WEST SUSSEX COUNTY COUNCIL CONSULTATION

TO:	Arun District Council FAO: Amber Willard
FROM:	WSCC - Highways Authority
DATE:	18 March 2019
LOCATION:	5 Hobbs Court Bilsham Road, Arundel, BN18 0JY
SUBJECT:	Y/9/19/HH New crossover to single dwelling. This application may affect the setting of a listed building. Amendment received.
DATE OF SITE VISIT:	N/A
RECOMMENDATION:	Advice
S106 CONTRIBUTION TOTAL:	£N/A

SECTION THROUGH NEW CROSSOVER

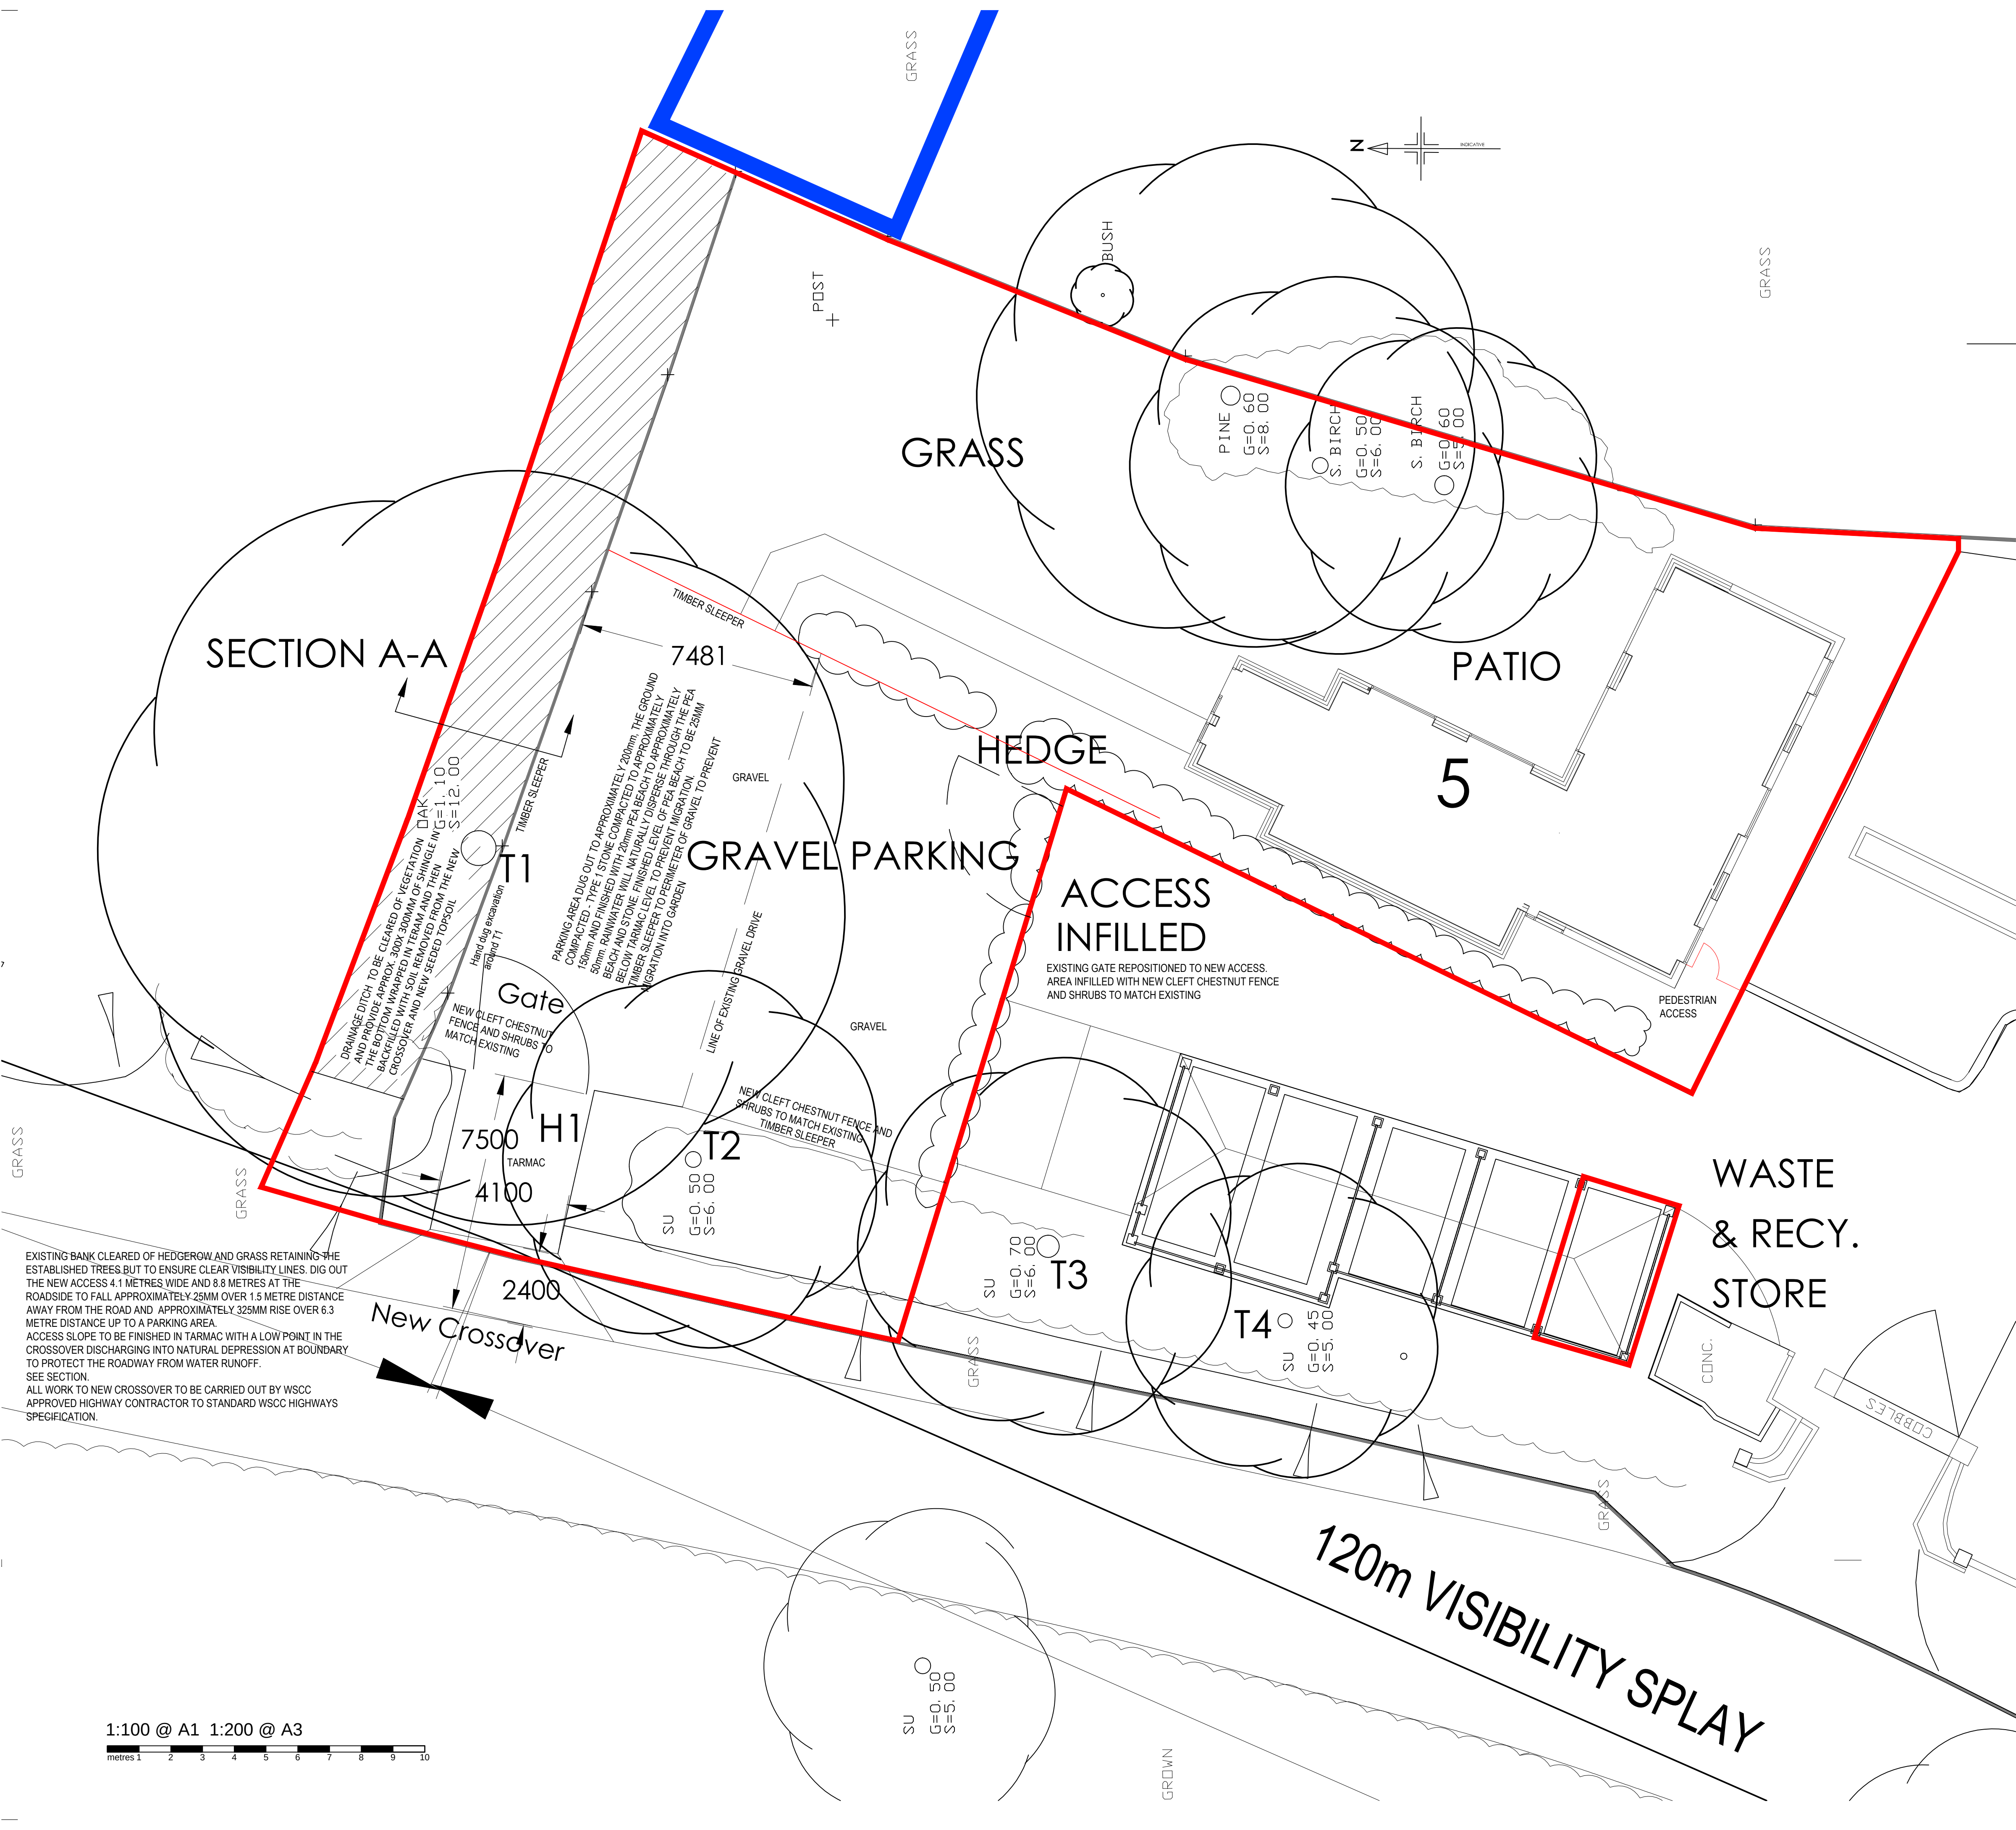
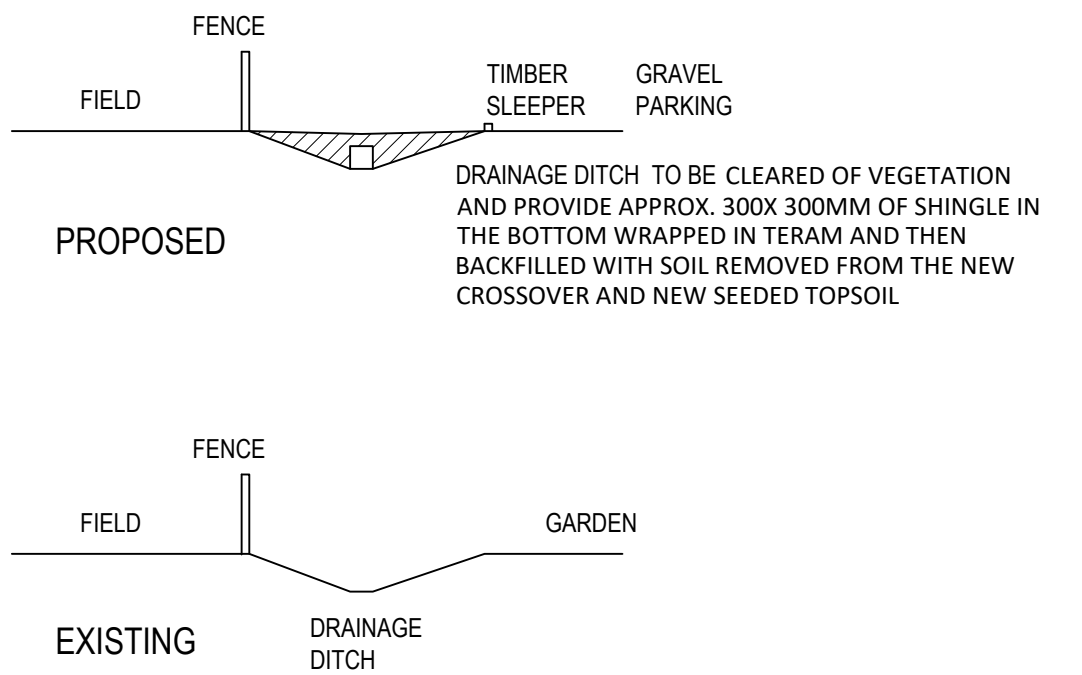
The use of the car parking and turning spaces shall not commence until such time as the vehicular access has been constructed in accordance with the details shown on the drawing titled Proposed Site Block Plan- Drawing number 011B.

The use of the access shall not commence until such time as the parking and turning area has been constructed in accordance with the details shown on the drawing titled Proposed Site Block Plan - Drawing number 011B. These spaces shall thereafter be retained at all times for their designated purpose.

REV	DATE	AMENDMENT	BY
PROJECT THE POTTING BARN HOBBS COURT, BILSHAM ROAD YAPTON, SUSSEX. BN18 0JY			
DRAWING SITE LOCATION AND BLOCK PLAN PROPOSED			
Date	Dec 2018	Drawn By	PJC
Scale	1:1250 / 500 @A3	Iss. App. By	DKC
Drawing No	010 B	File Location	0221

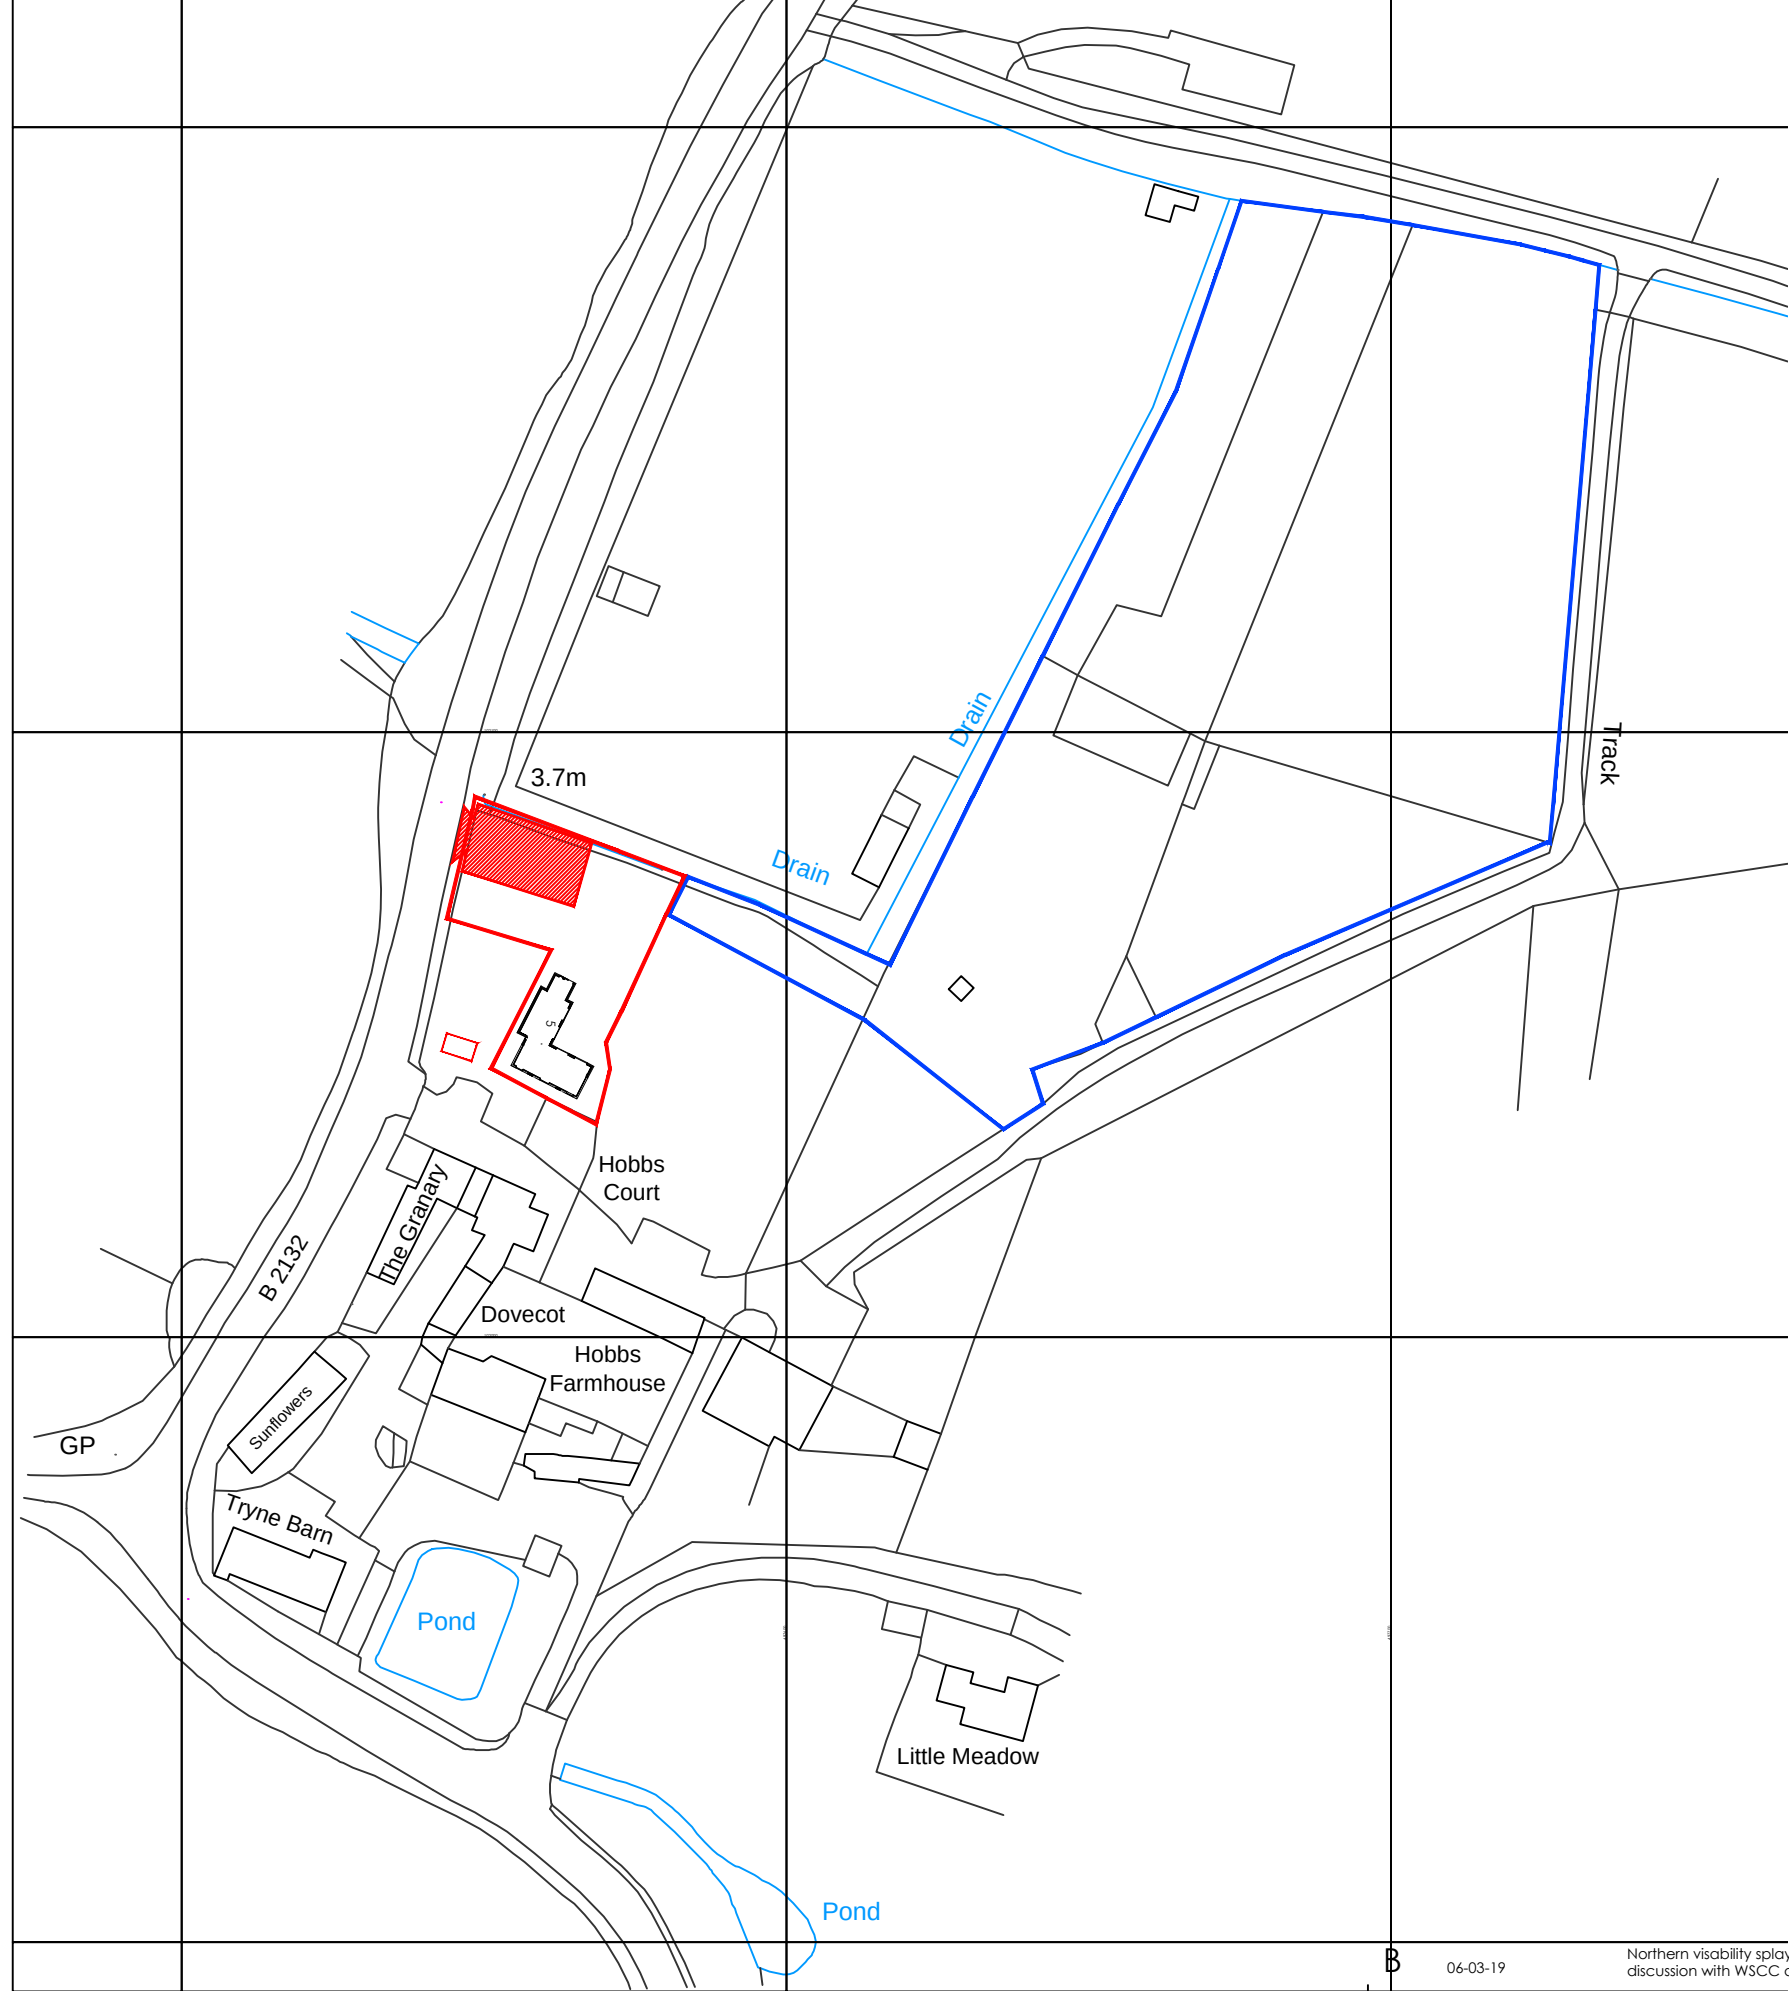
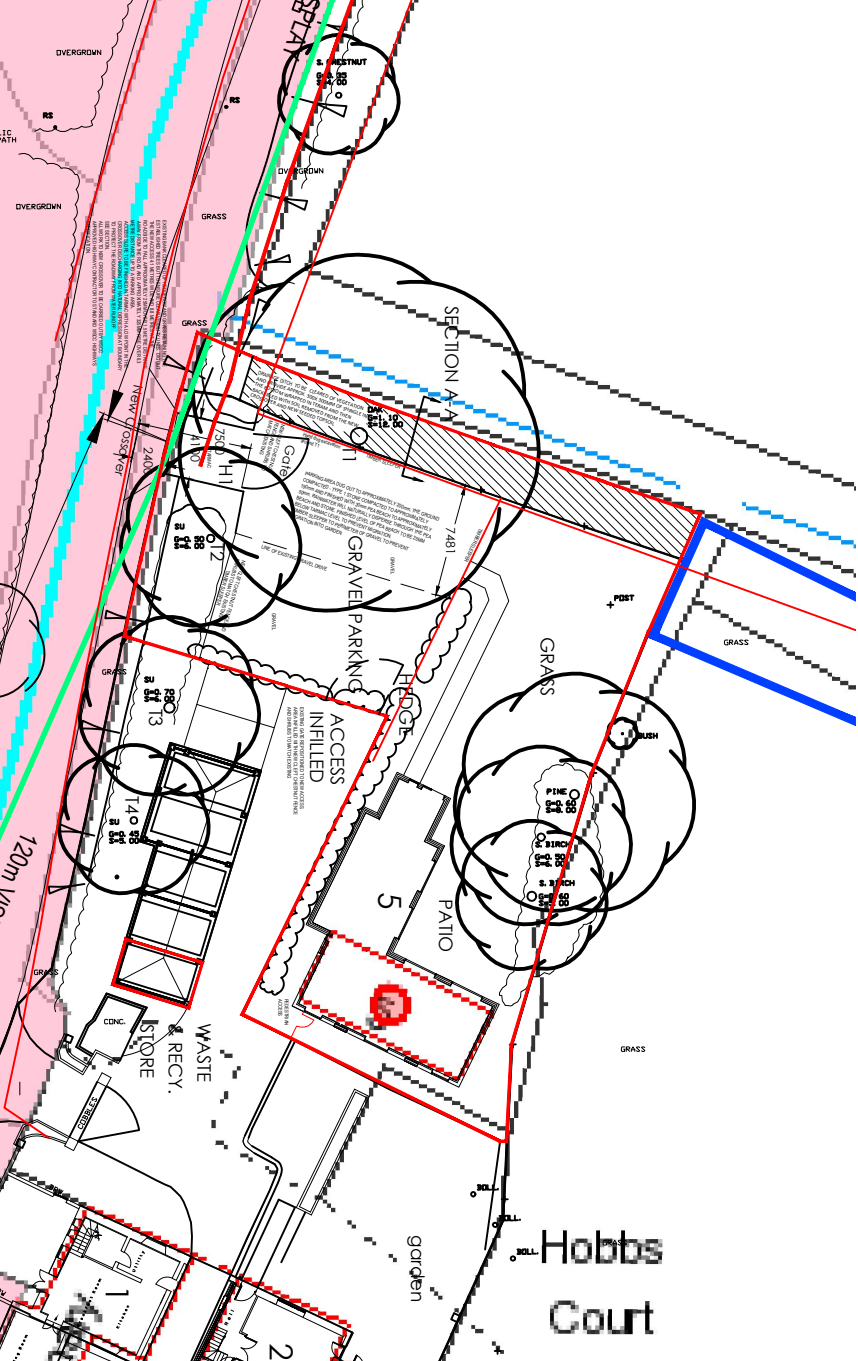
A one day speed survey was undertaken in May 2015 which recorded speeds of approximately 28mph in each direction, albeit closer to the double bend to the south. The technical drawings submitted at that time indicated achievable splays of 2.4m x 120m to the south and 2.4m x 116m to the north and these splays were accepted by the LHA at that time. The LHA are not aware of any major changes within the highway network in this location that would require an additional speed survey to be conducted for this small scale proposal. The applicant has demonstrated splays of 2.4m x 120m to the south and 2.4m x 116m to the north on the current plans. As such the LHA is satisfied that this proposal is not anticipated to result in a highway safety concern in this location.

No part of the development shall be first occupied until visibility splays of 2.4 metres by 120 metres to the south and 2.4 metres by 116 metres to the north have been provided at the proposed site vehicular access onto Bilsham Road in accordance with the details shown on the drawing titled Proposed Site Block Plan - Drawing number 011B. Once provided the splays shall thereafter be maintained and kept free of all obstructions over a height of 0.6 metre above adjoining carriageway level or as otherwise agreed.
